Application Ref:	3/2025/0952			 Ribble Valley Borough Council www.ribblevalley.gov.uk
Date Inspected:	N/A	Site Notice:	N/A	
Officer:	LW			
DELEGATED ITEM FILE REPORT:				APPROVAL

Development Description:	Certificate of Lawfulness for proposed loft conversion.
Site Address/Location:	Annexe 47 Elevedene, Lower Lane, Longridge, PR3 3SQ.

**PROPOSED SOUTH WEST ELEVATION**  
Scale 1:100

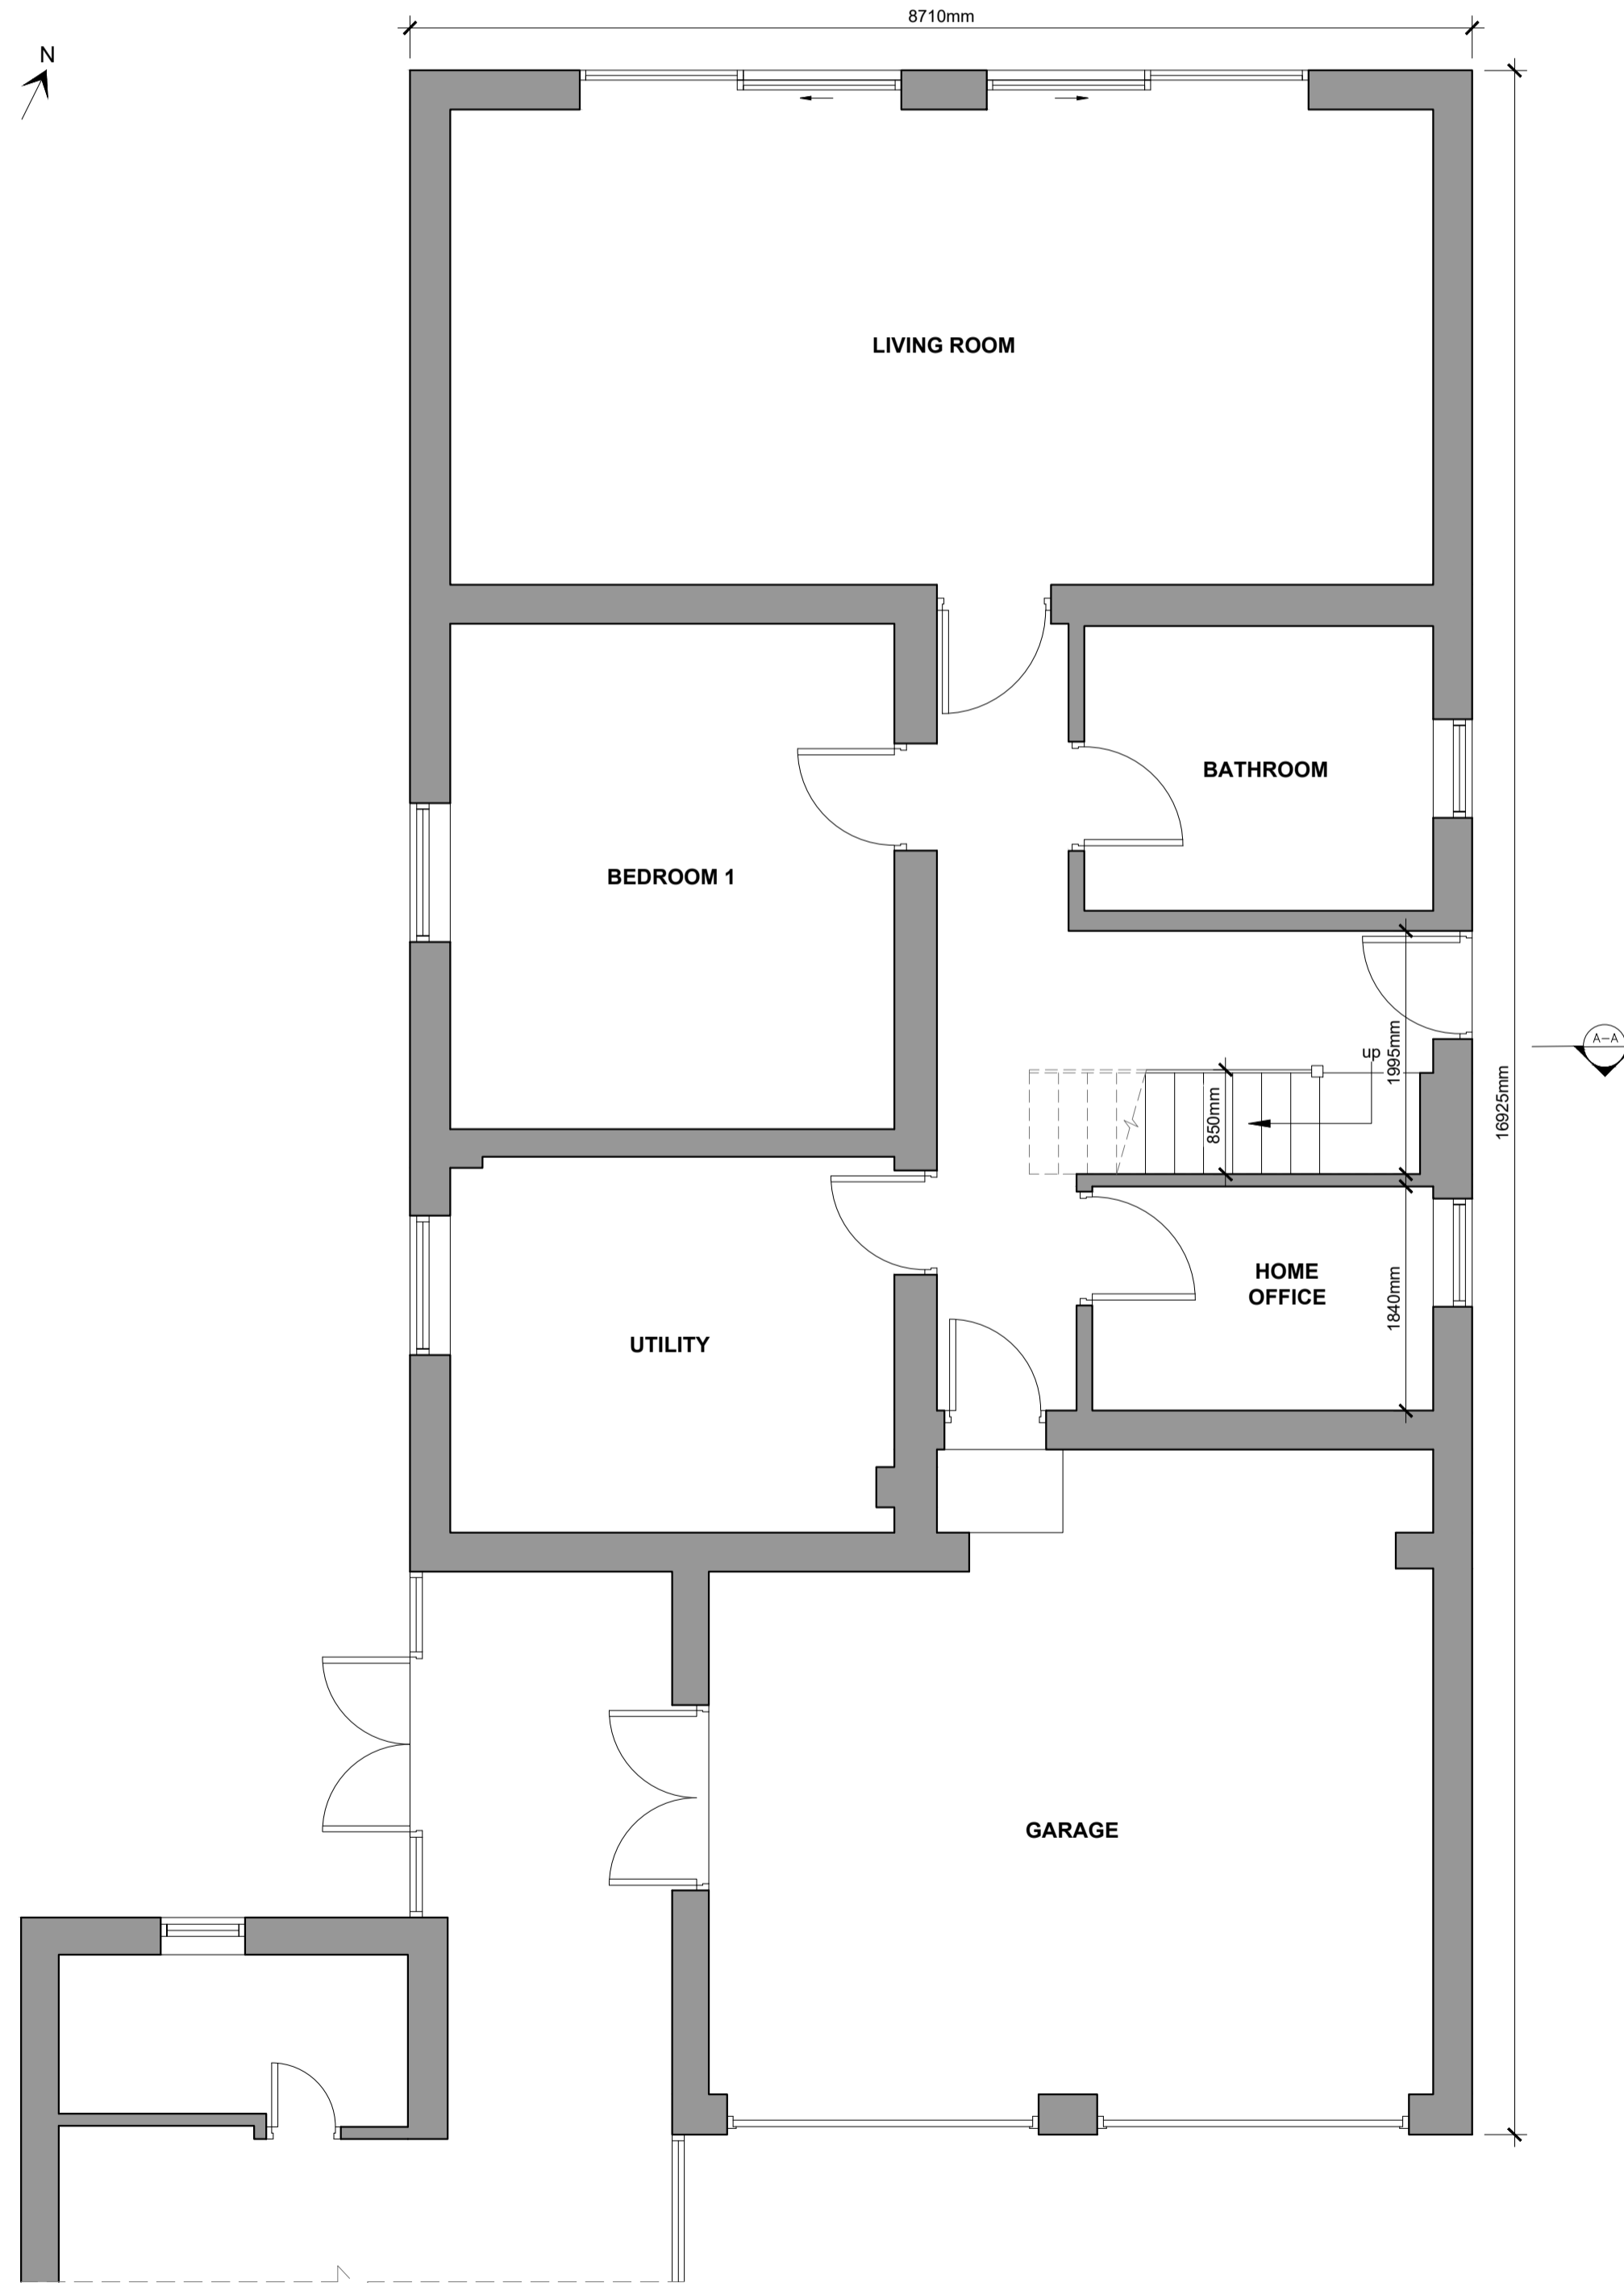
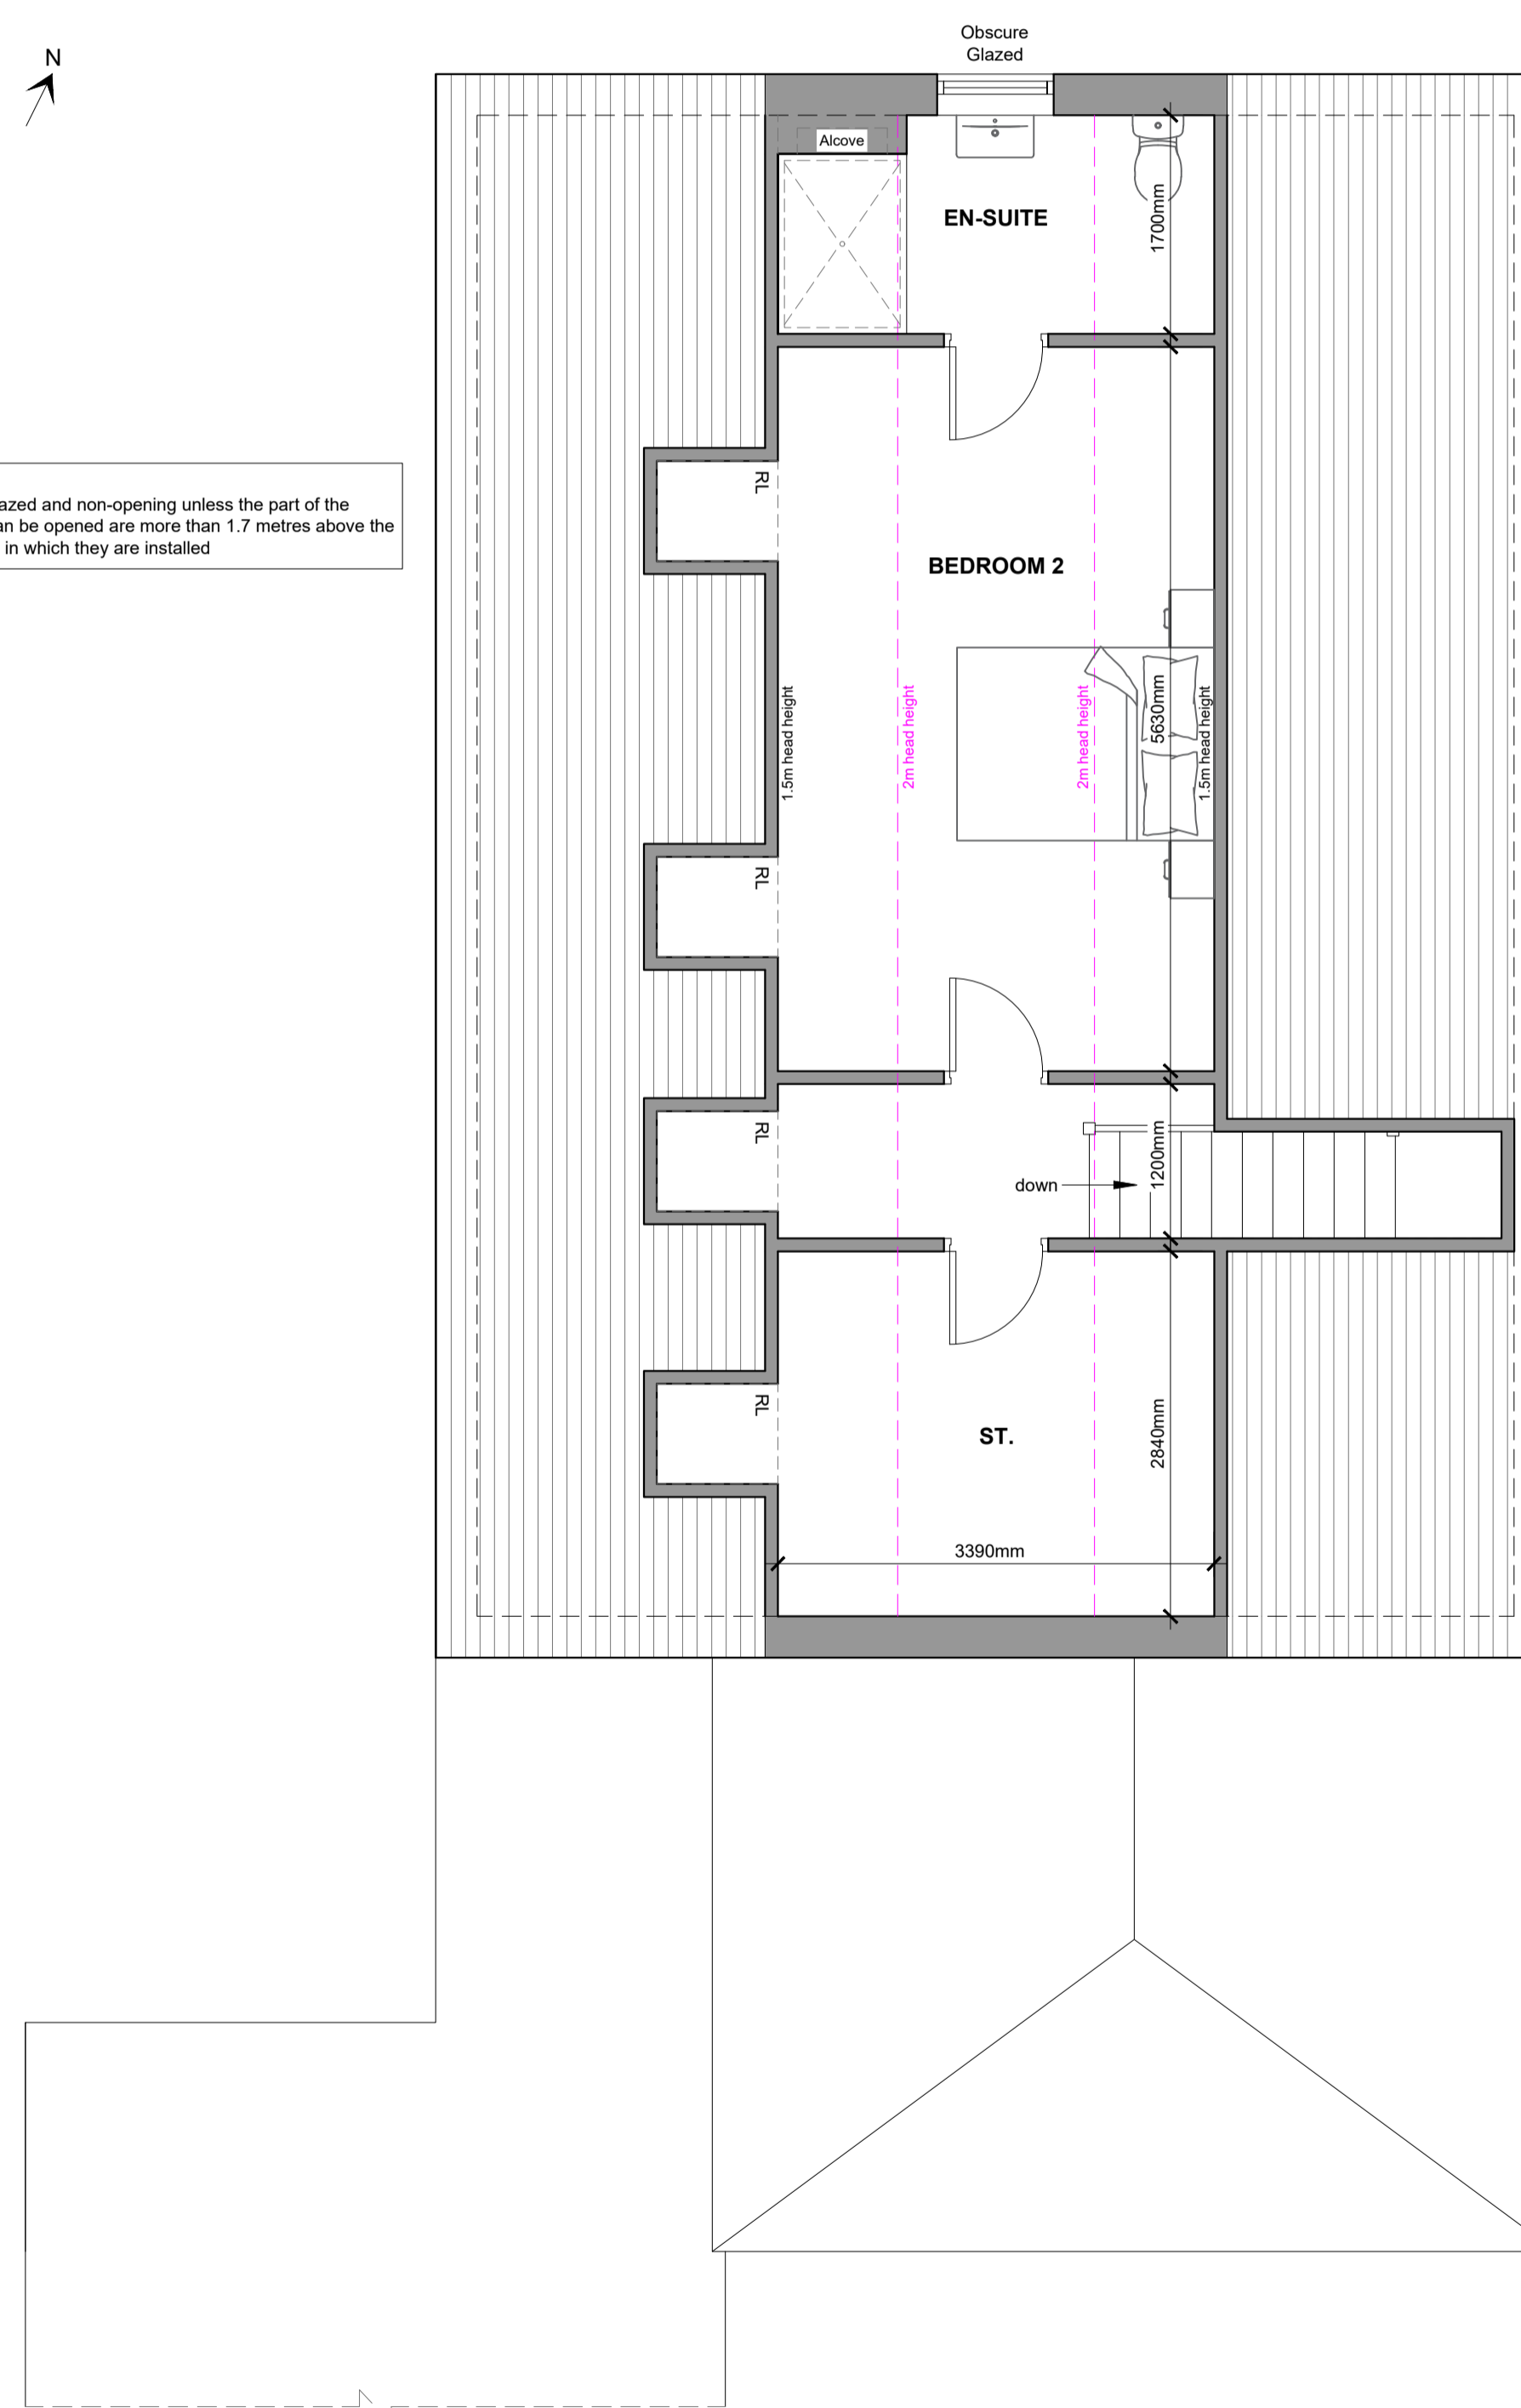
The proposed rooflights would be located on a roof slope forming a side elevation of the dwellinghouse; however, the plans received on 15th January 2026 show the rooflights to be obscure glazed and non-opening. The development therefore complies with the above.

The proposed development, as detailed on amended plan dwg no. 2536-02 Rev A, constitutes permitted development under Schedule 2 Part 1 Class C of the Town and Country Planning (General Permitted Development) (England) Order 2015 (as amended), subject to the condition outlined in C.2 of this Part.
